3A10/1003SW (D13/102536)

MP09_0088

3 May 2013

**Shoalhaven Water Response – Exhibition of Environmental Assessment
for Concept Approval – Mixed Use Subdivision, West Culburra
(MP09_0088)**

M:\Projects\20000250006\25405 Drawings\25405-232-249-STAGING PLANS-Rev 1.dwg

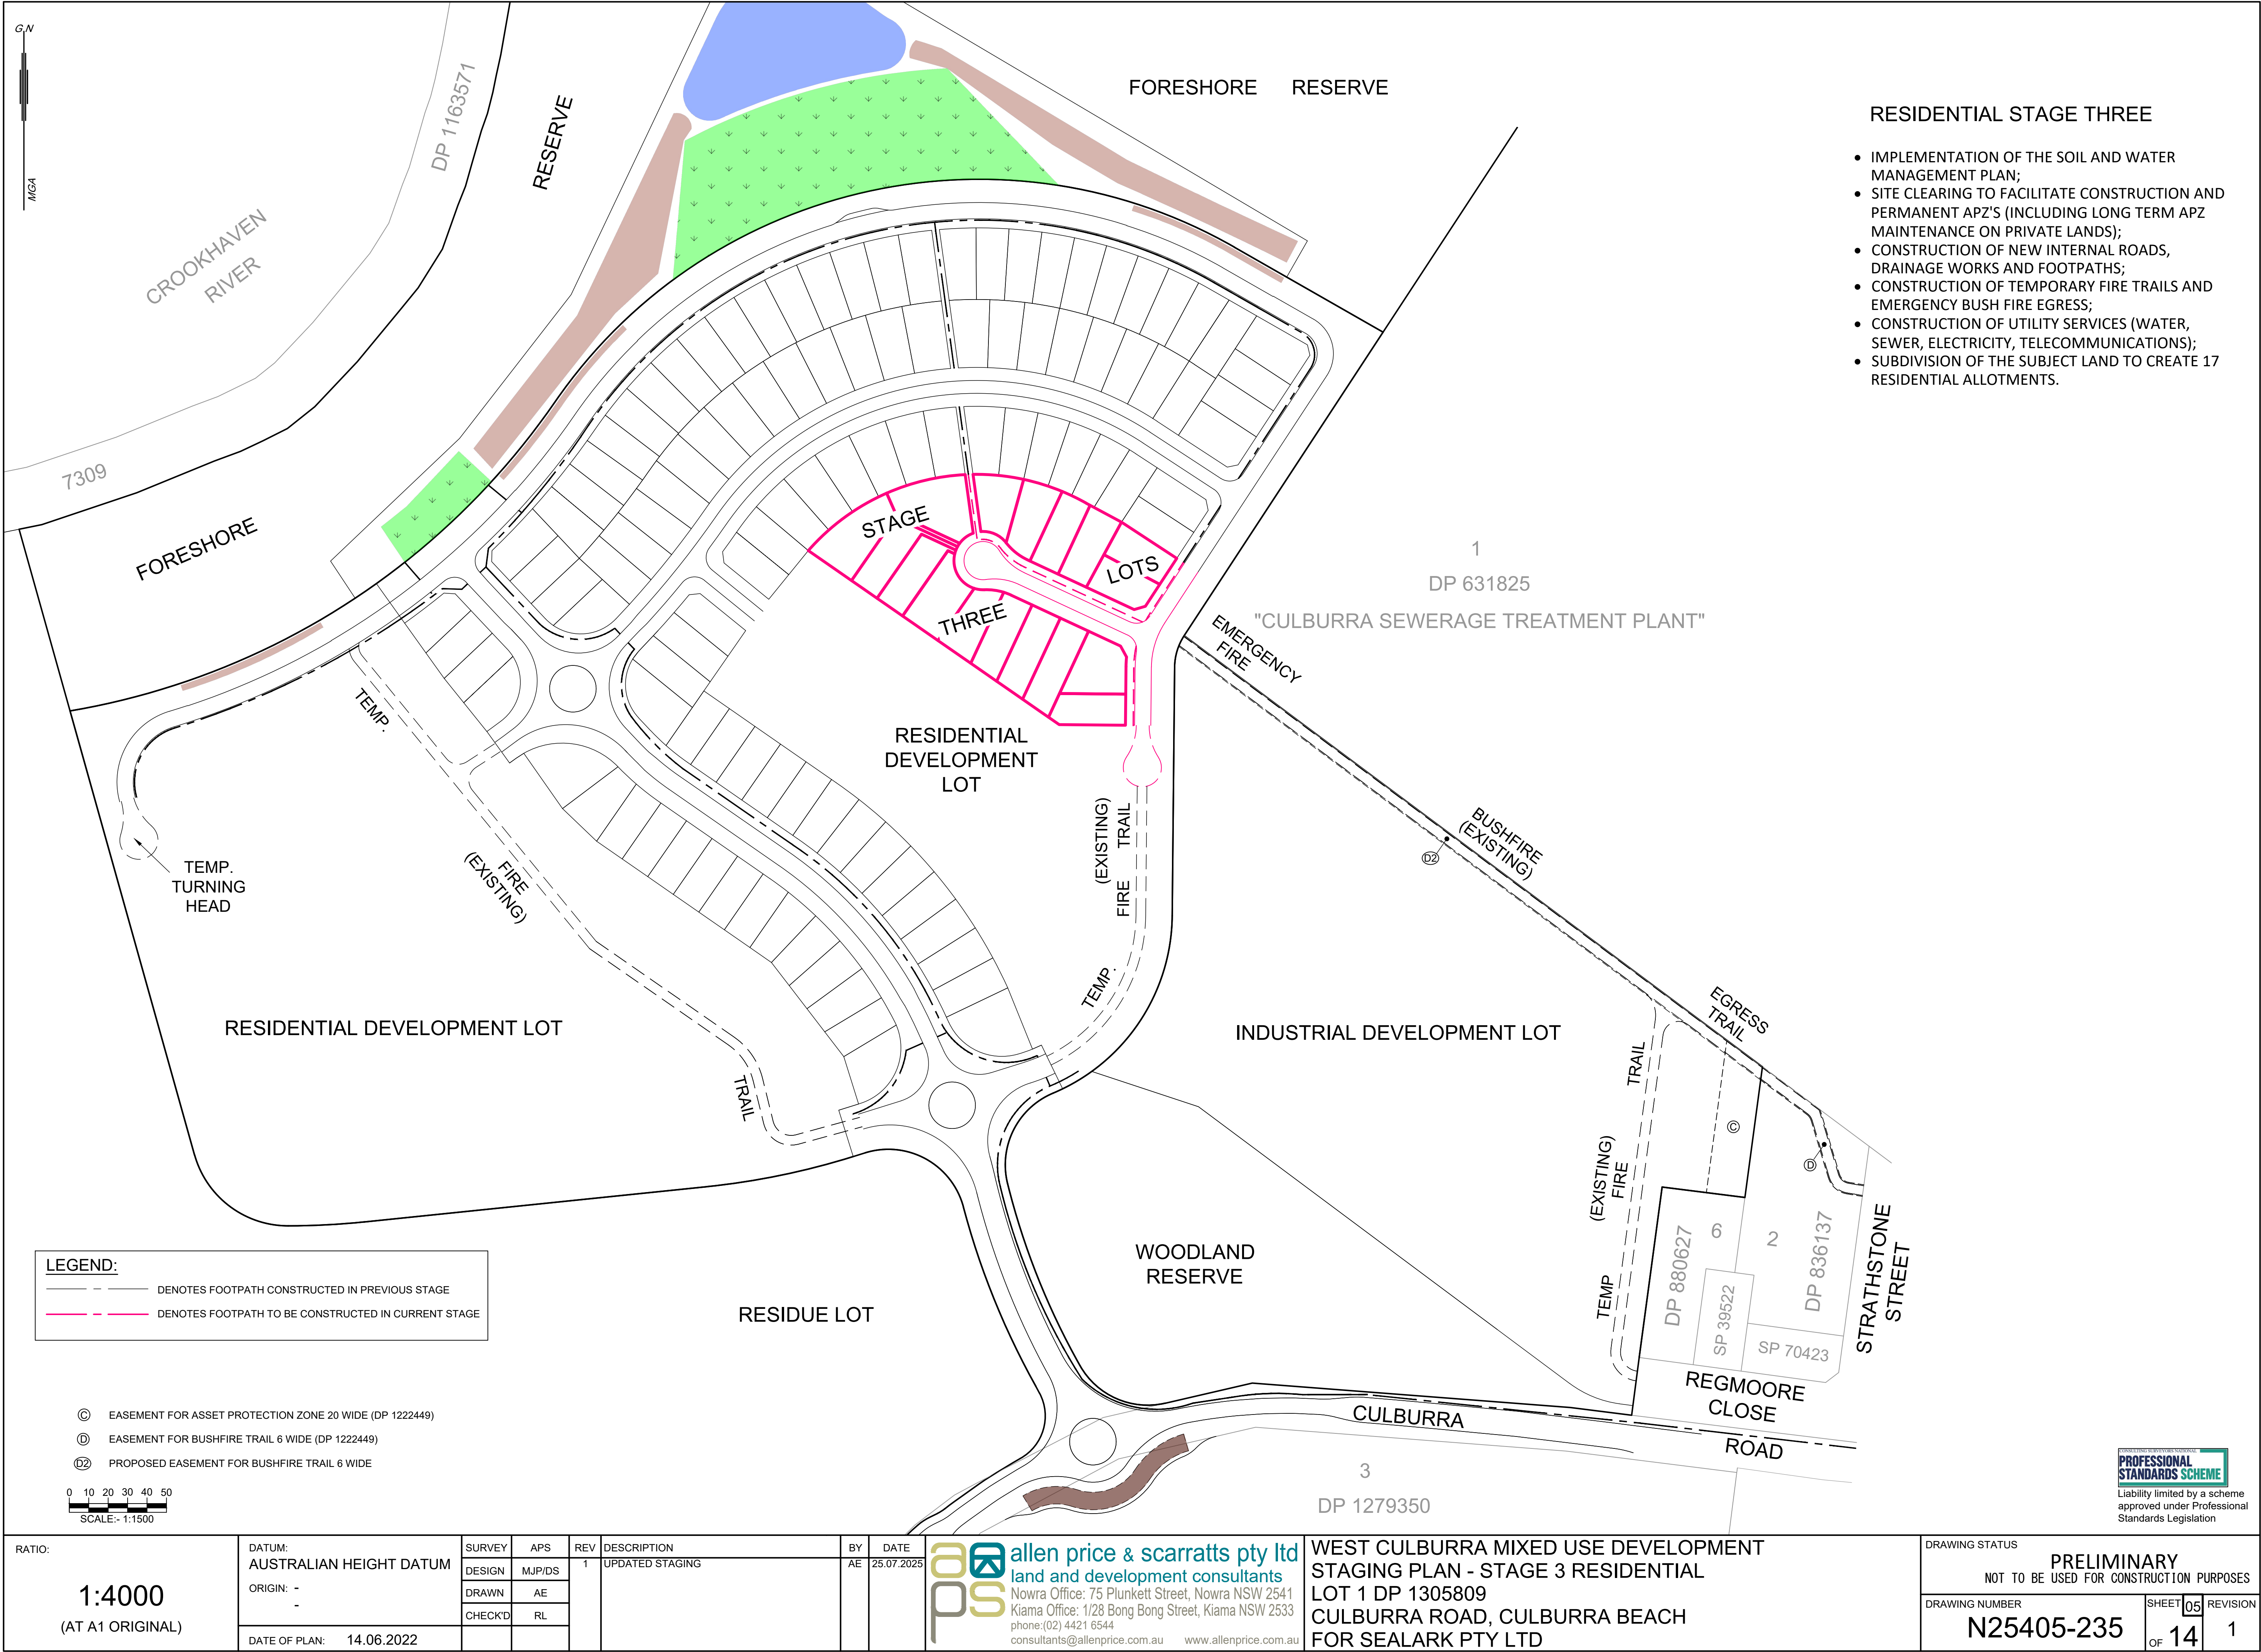
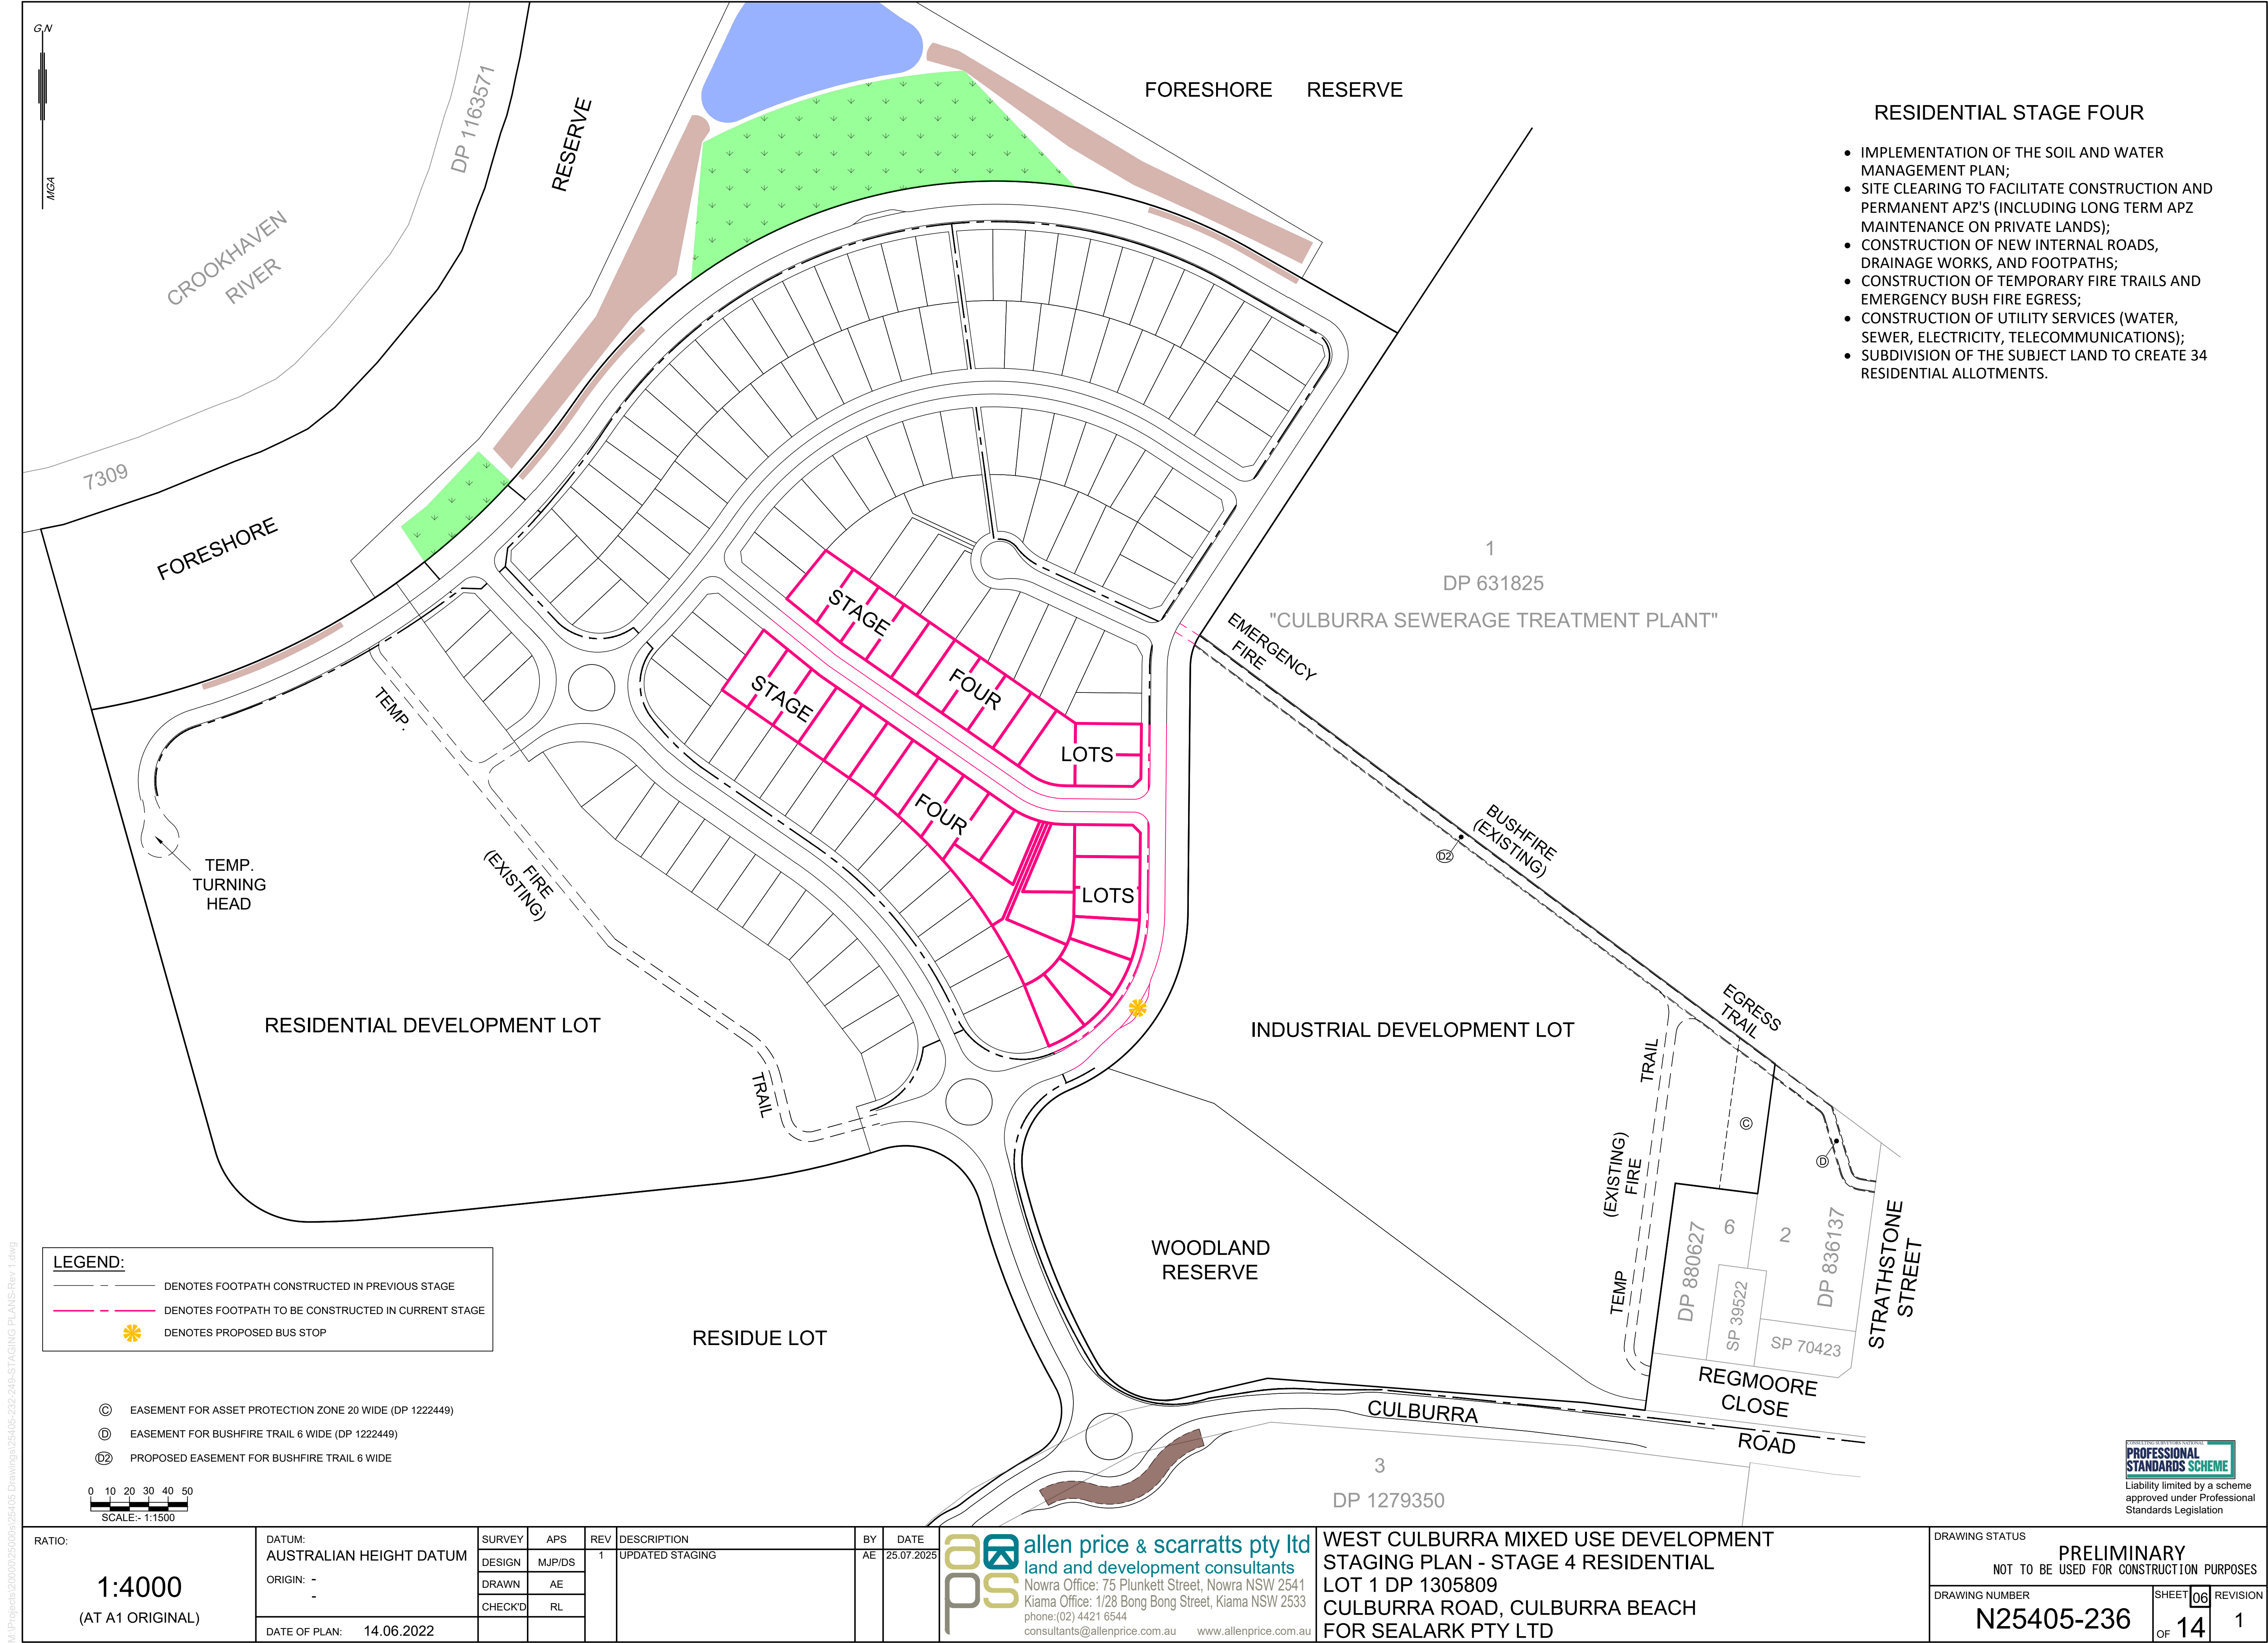
- An existing 225mm DICL & 375mm DICL sewer rising main (SRM) is located within an easement within lot 6 DP 1065111, Shoalhaven Water will not permit the construction of any structure within the boundary of the

easement or within the zone of influence of the existing pipe. The applicant shall consider the location of the existing 225mm SRM and easement during design. Any proposed relocation of this main shall be determined after detailed consultation with Shoalhaven Water.
